Application by Highways England for TR010031: A1 Birtley to Coal House Improvement Scheme

The Examining Authority's further written questions and requests for information (ExQ3)

Issued on 26 May 2020

Site:	LAMESLEY AGI
Title:	PLANNING DRAWING SITE PLAN - PROPOSED
Orig. Ref.:	
Drg No.:	952-06-DG-0052
Revision	1

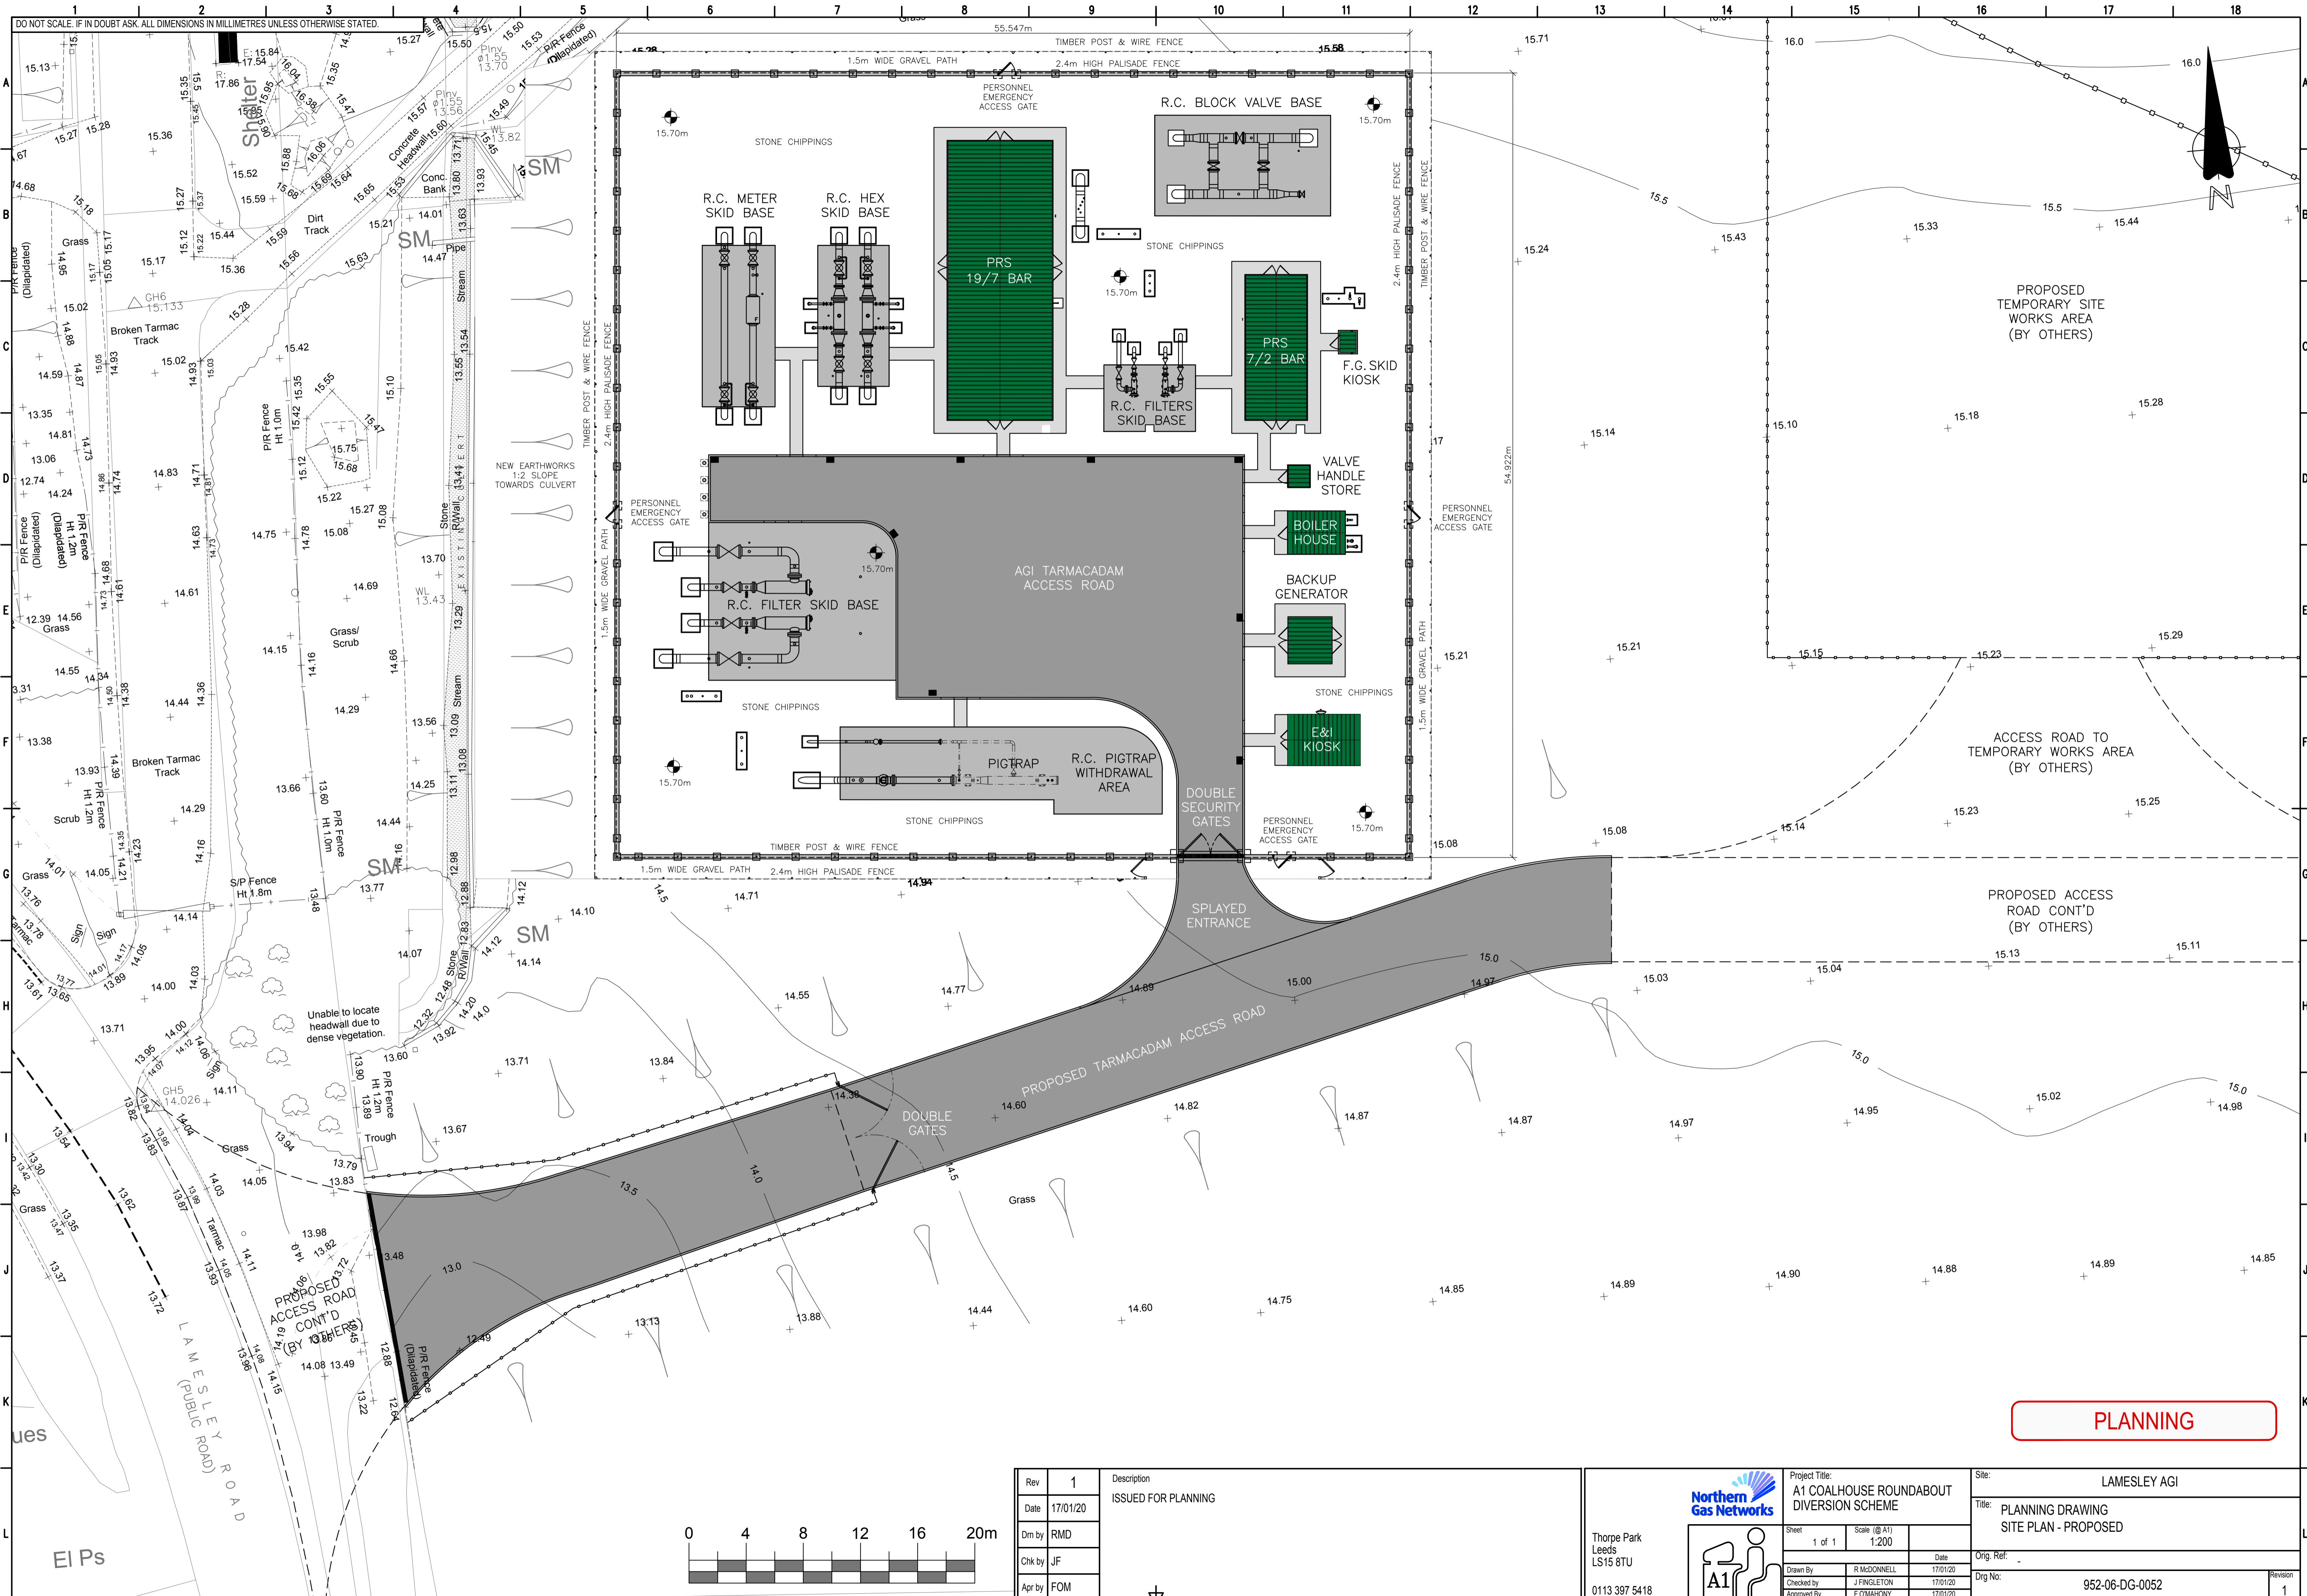
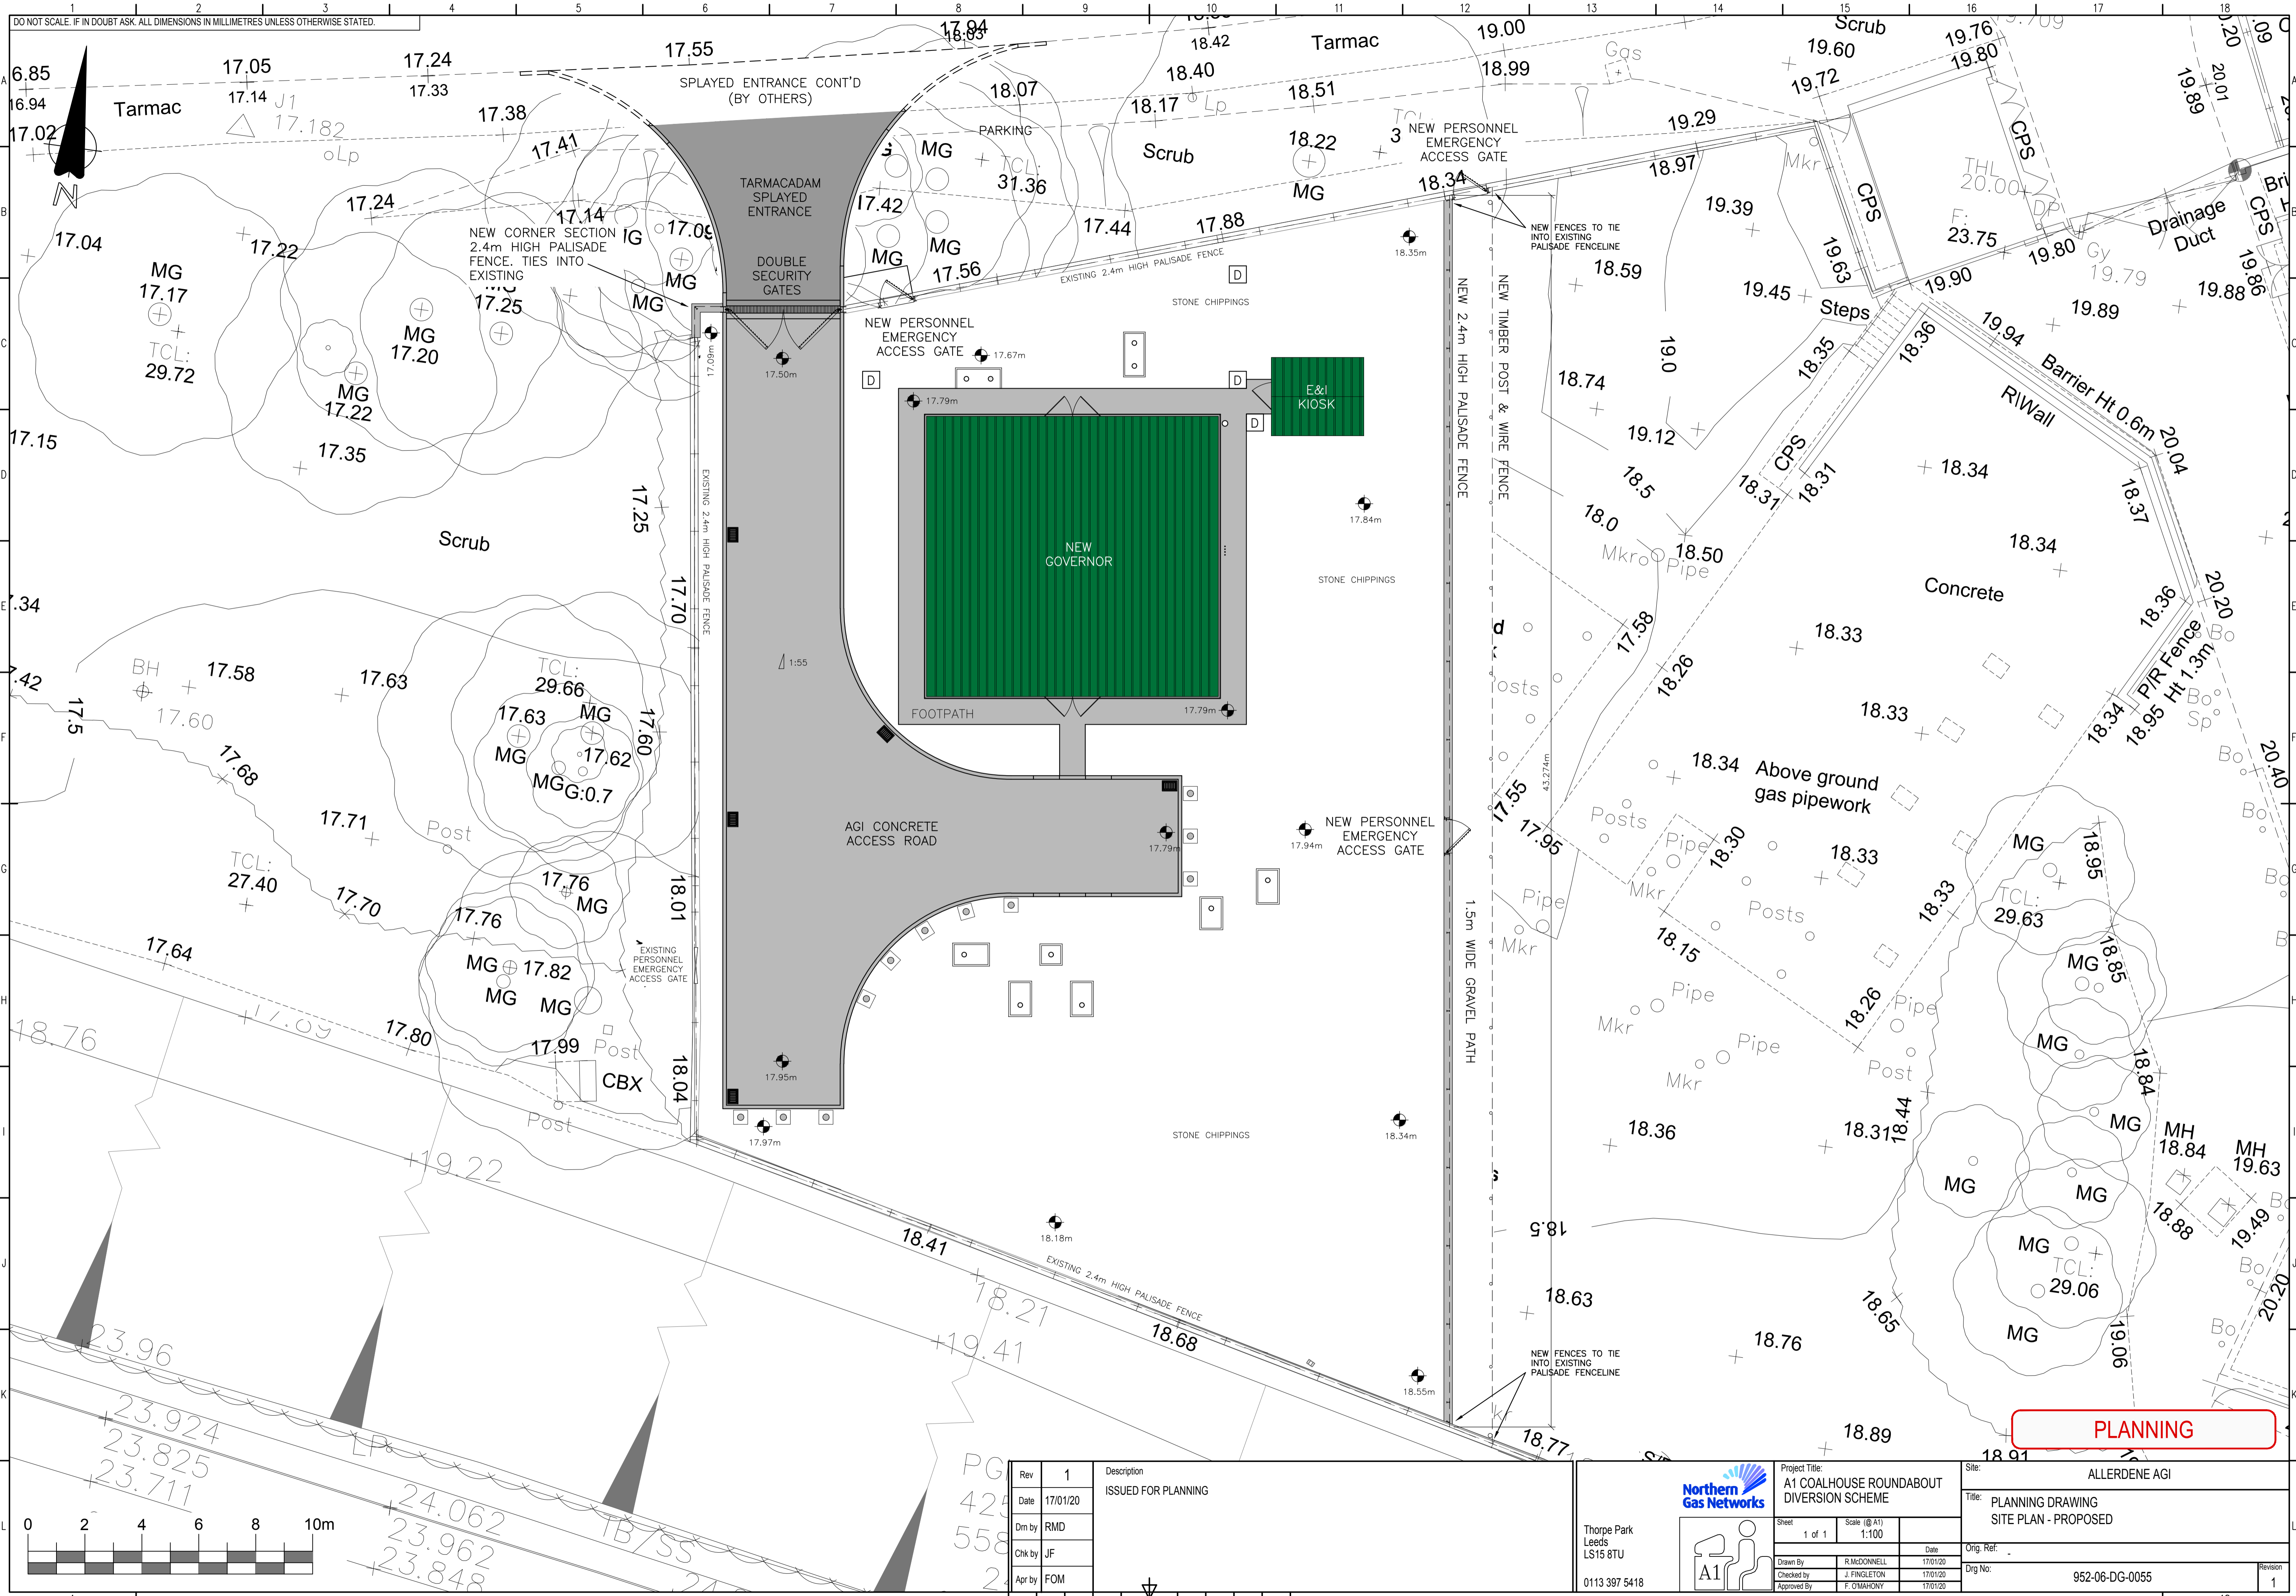
3.4.3	Applicant and Gateshead Council	<p>The Applicant has provided further details of the existing (to be demolished) and proposed Northern Gas Network (NGN) installations [REP4-041 and REP4-081]. The removal of the existing installation is included as a consideration in assessing the impact upon Green Belt openness.</p> <p>a) How would the demolition of the existing NGN installation be secured within the DCO? Please provide any additional drafting necessary to secure this.</p> <p>b) Notwithstanding the amendments made to Requirement 3 and additional details provided, do further details of the parameters of these works (Nos.10 and 12), including scale and height, need to be secured through the DCO. If not, please explain why?</p> <p>c) Requirement 3(3) requires subsequent approval of the <i>external appearance</i> of Work Nos. 10 and 12. For clarity and precision, should the drafting of Requirement 3(3) also include the need for details of layout and scale to be approved?</p>
